# CITY OF ALBUQUERQUE

October 30, 2015

**RE: Abraham – Beach Property  
Drainage and Grading Plan  
Engineer’s Stamp Date 9-14-15 (File: F16D003E1)**

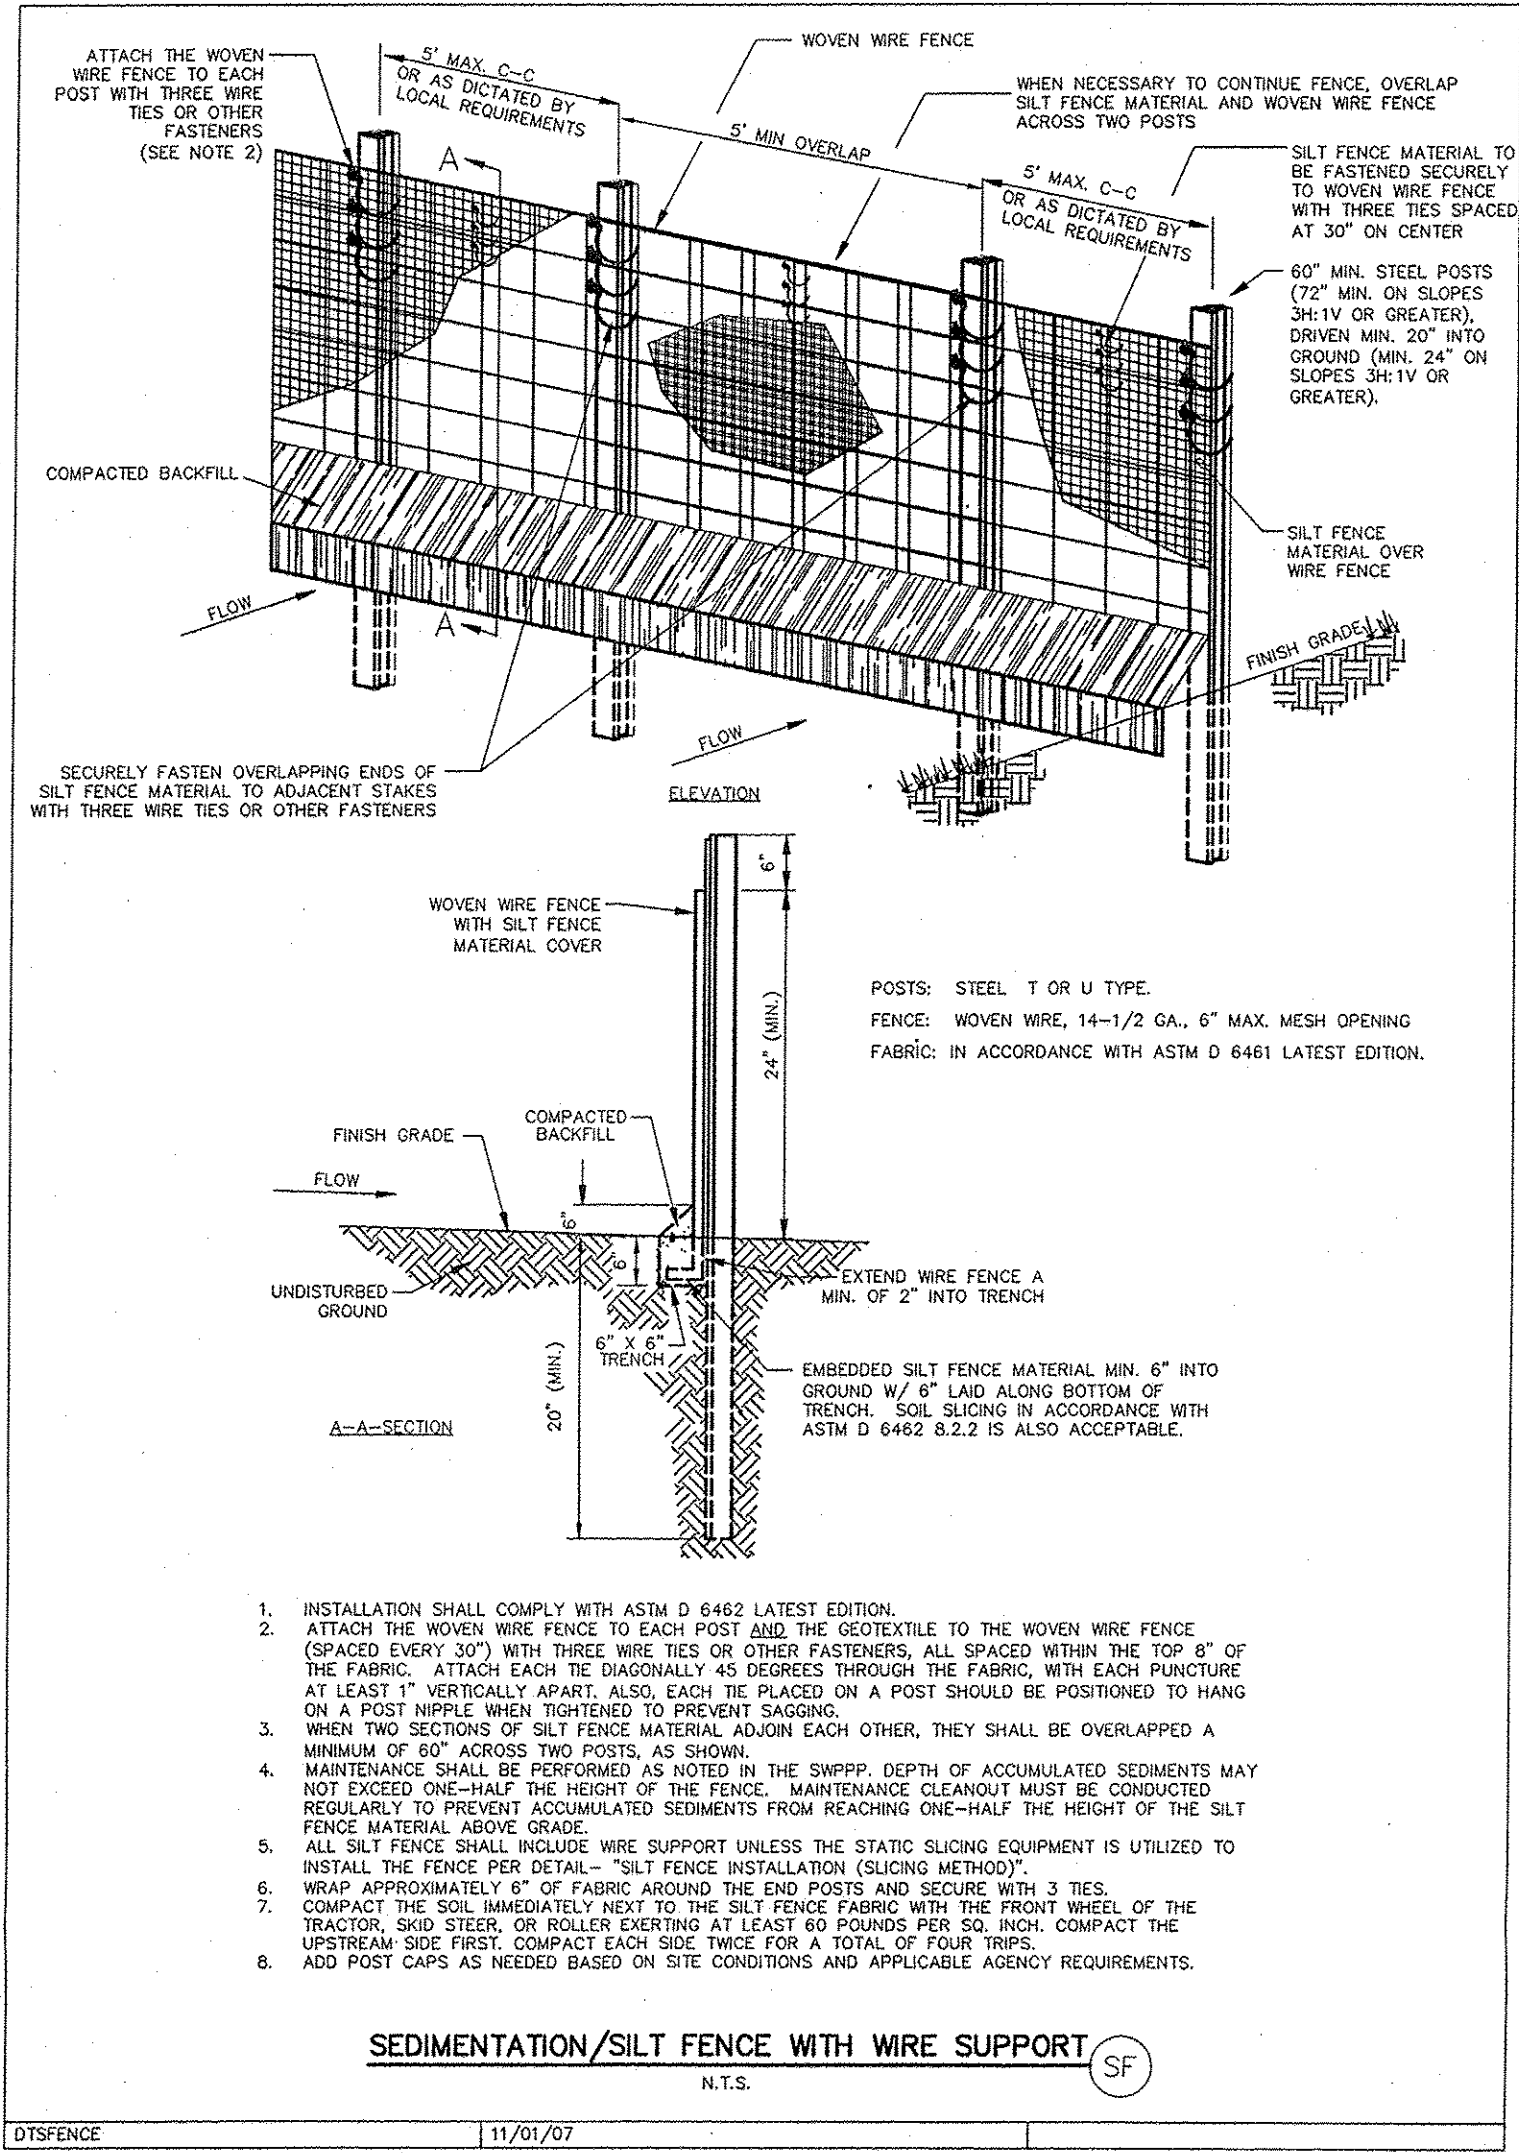
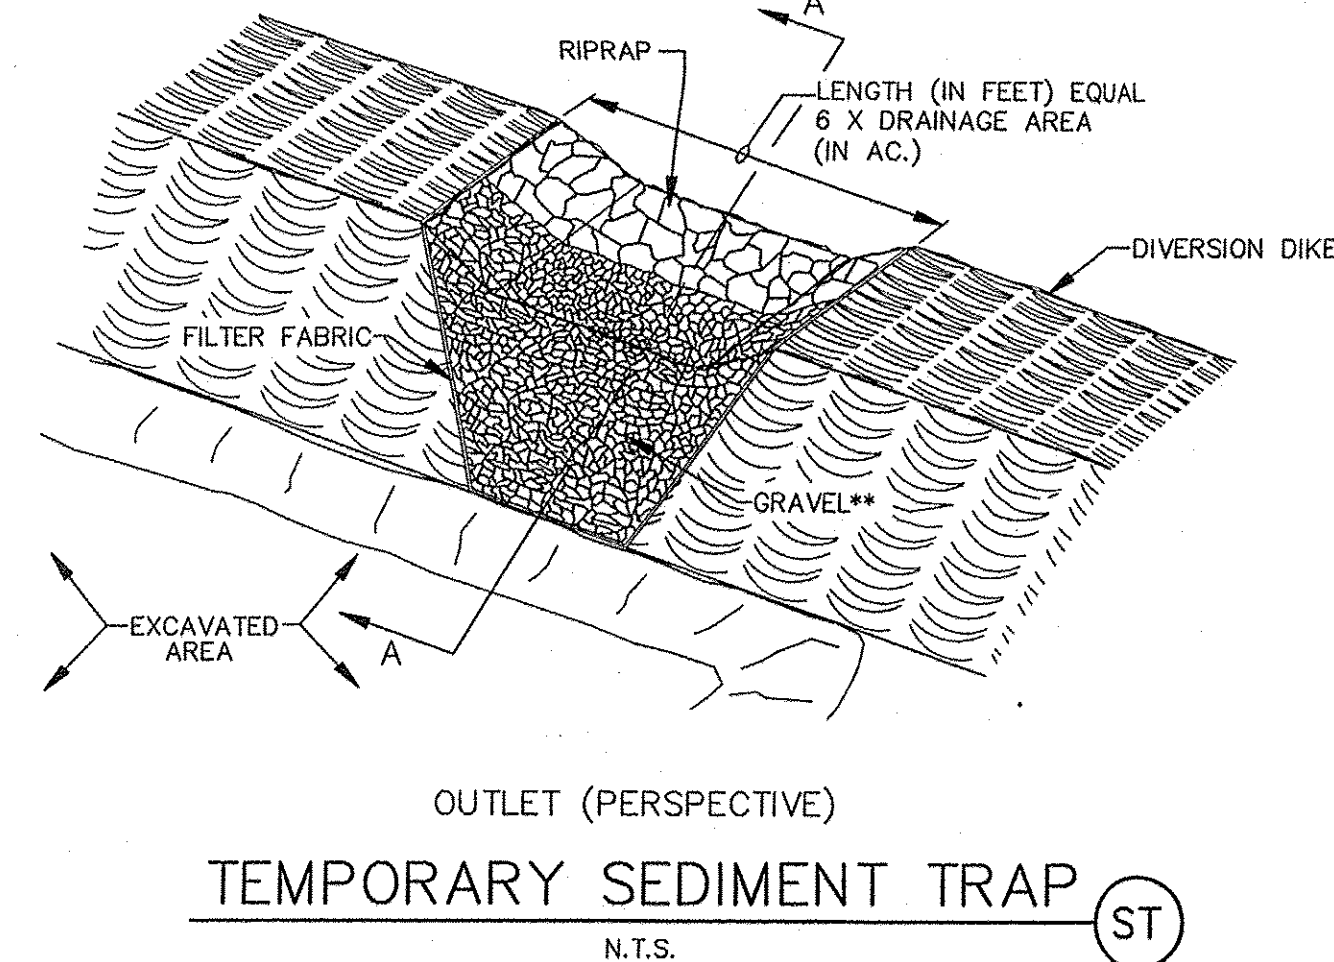
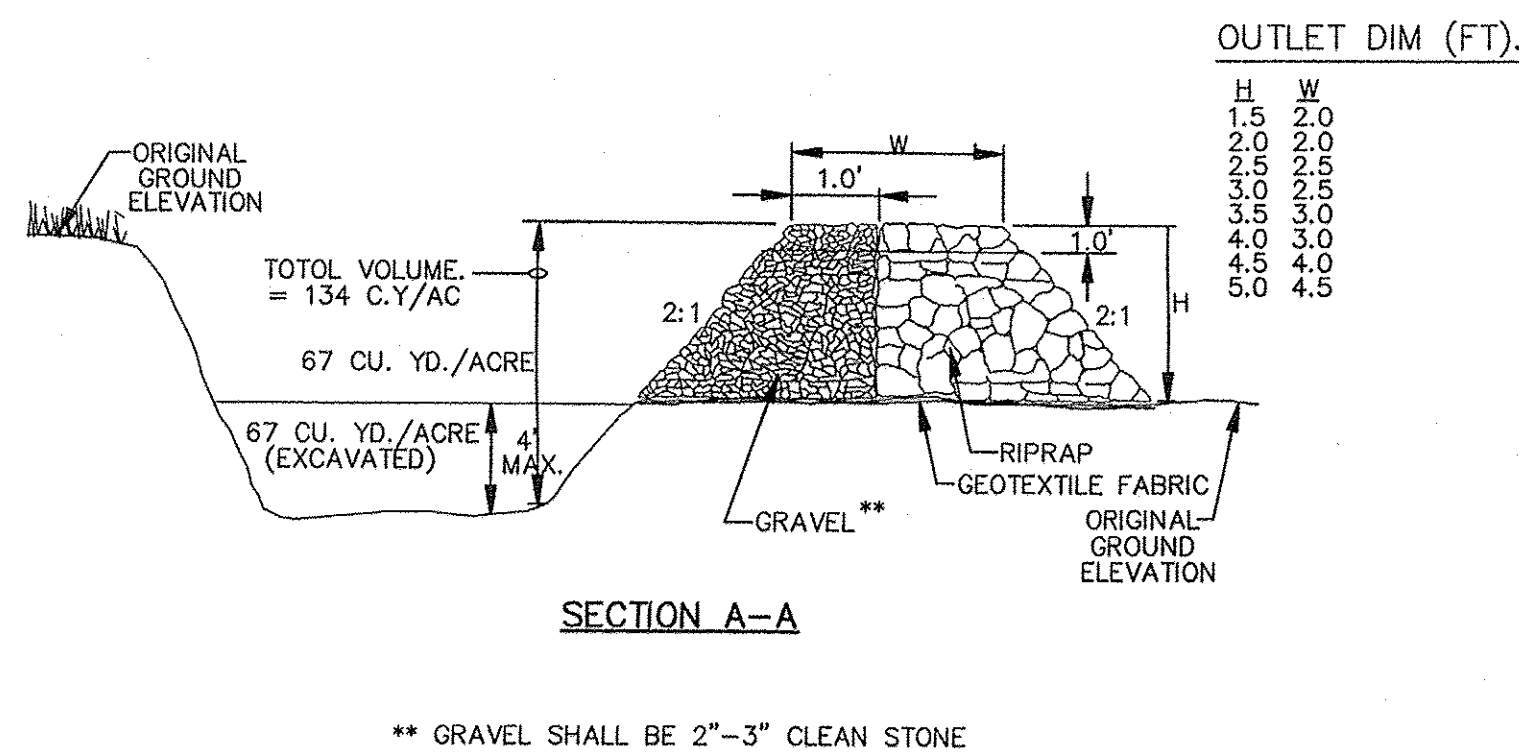
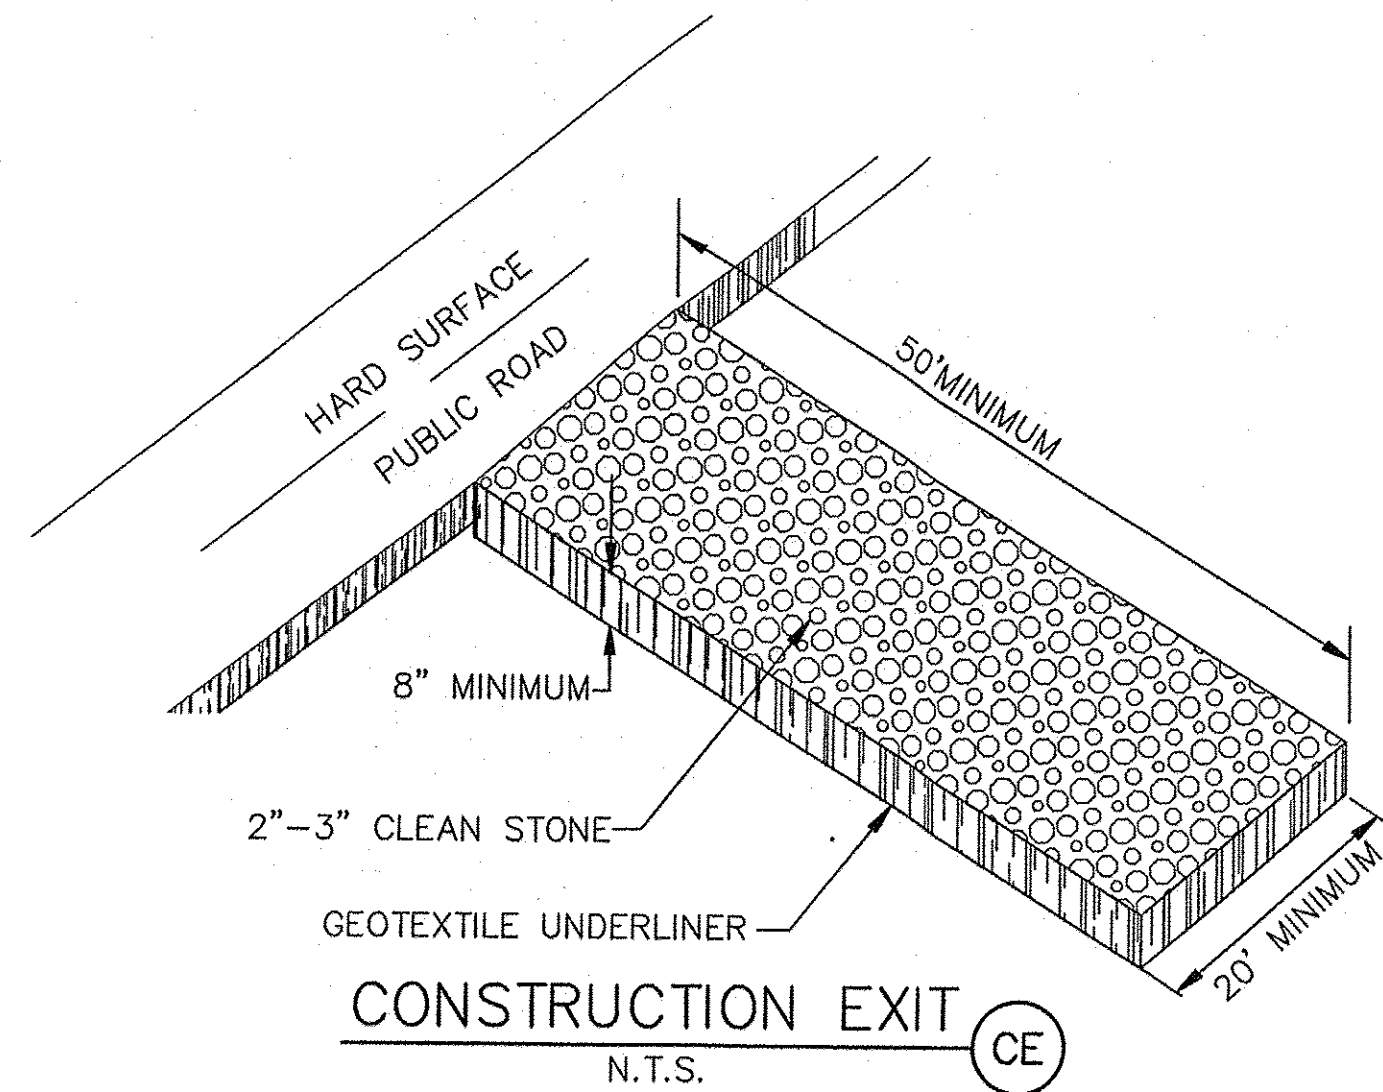
- The Basin Map on Sheet C2 references existing drainage that do not appear to match the proposed layout. Correct the Existing Drainage Condition language to reflect the fact that Basins 1 and 3 do not drain to the detention pond.

- The Proposed Drainage Condition language on Sheet C2 does not seem to be associated with this project (e.g., references to the “Frito Lay pond” and mismatched Basin numbers).

- The Northeast corner of the pond is graded in a manner that encroaches into the access aisle of the parking lot of Basin 7.
- Basin 9 quantified in the calculations appears to refer to the Shell/McDonald’s/Starbucks development. It should be labeled on the Basin Map.
